Planning Application Ref: CM/37/18/OUT

Location: Mistletoe Farm, Horsemere Green Lane, Climping BN17 5QZ

Description of works: Outline application with some matters reserved for the redevelopment of site with 2 no. 4-bed detached bungalows & associated works (resubmission following CM/10/18/OUT). This application is a Departure from the Development Plan.

Tree Officer / Parks and Greenspace Team

proposed block plan 1:500@A3

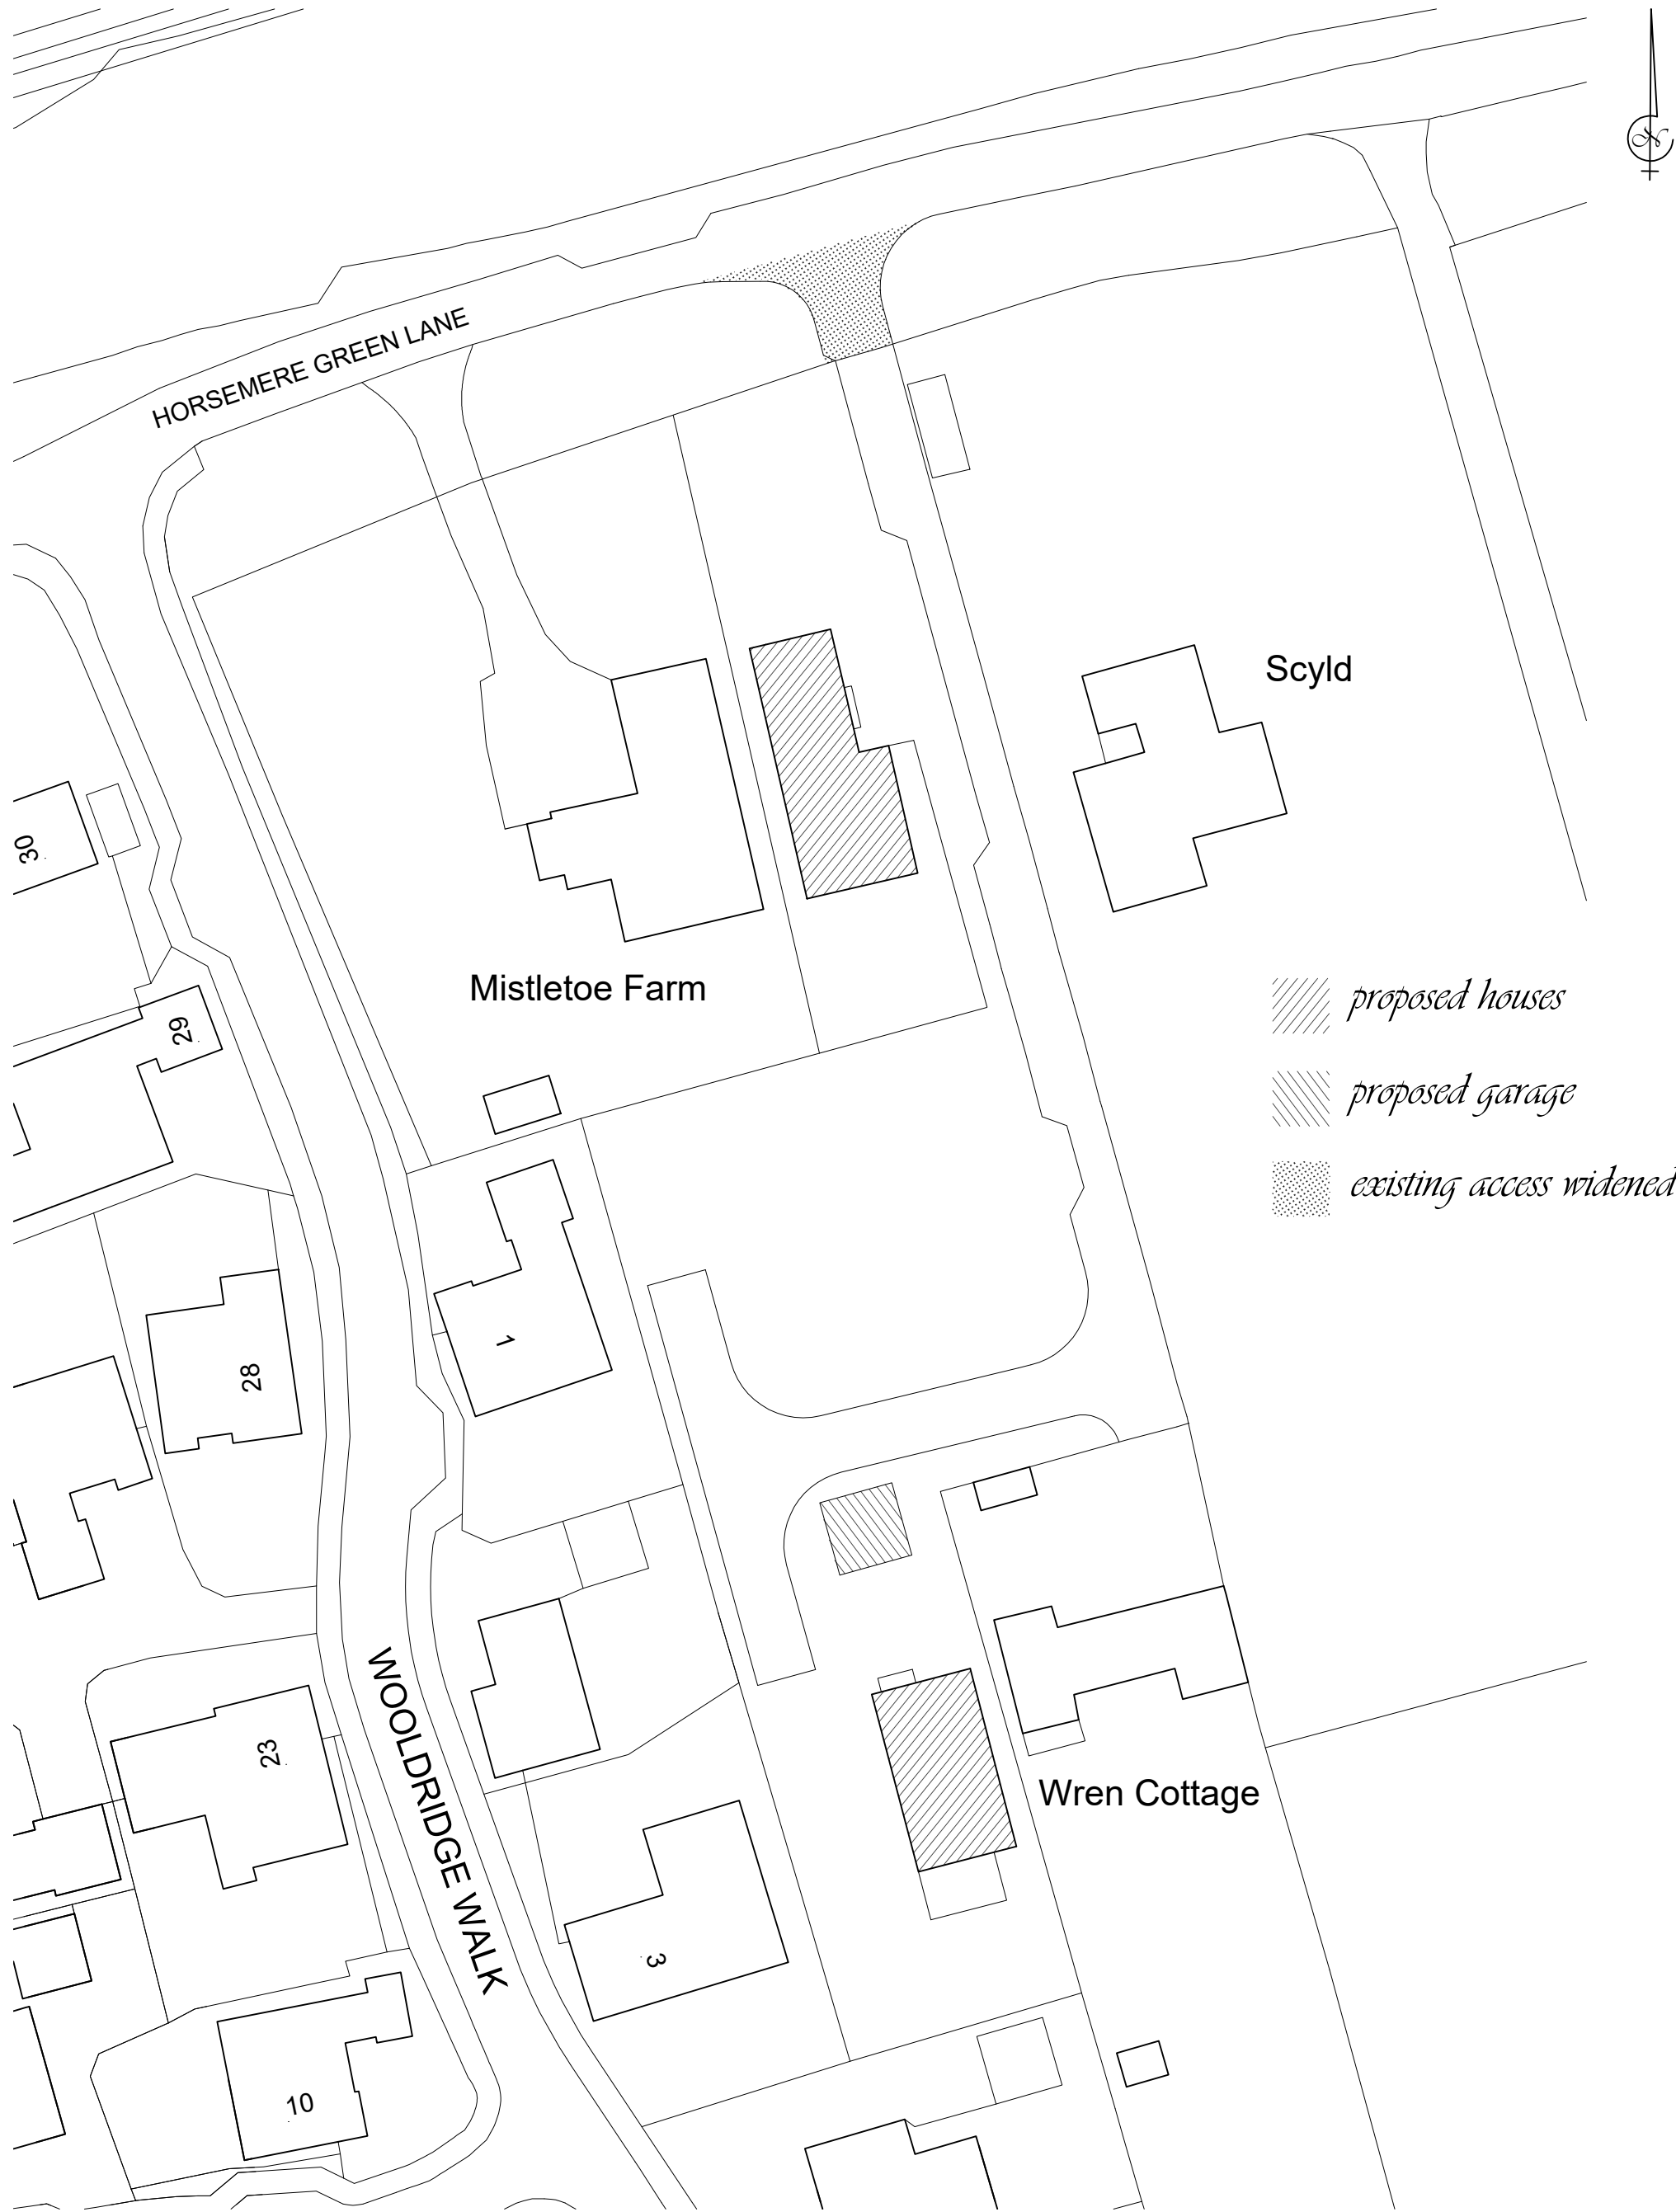
- The most valuable tree growing wholly on the site (T40 – beech) is now the subject of an Order (TPO) and should be considered sacrosanct. Companion trees which contribute to group cohesion and form an attractive arboricultural feature in the centre of the site – could and should be retained. They will add a visually attractive and mature outlook to this part of the development.
- The revised layout provides an opportunity to retain mature trees of value, although it is not yet clear exactly which trees are to be retained or removed across the site.

- I find the revised layout (essentially a reduction in units) to be far more acceptable, as it seeks to retain Category A and B trees previously identified for removal; although I remain concerned about the potential loss of trees across the site and risk of damage to third party trees along the site's eastern boundary.
- The existing tree schedule needs to reflect all and any changes to the original proposal and those must be shown on an updated tree retention and protection plan. The Arboricultural Impact Assessment and Arboricultural Method Statement must also reflect those changes where required, so that there can be no ambiguity and those documents can then form part of any subsequent condition.

- The applicant should, where relevant, provide us with an updated tree schedule, AIA, AMS and set of plans. On receipt of those, I should be in a position to lend this scheme my support and provide you with a number of standard conditions to ensure those trees retained are best respected and protected.
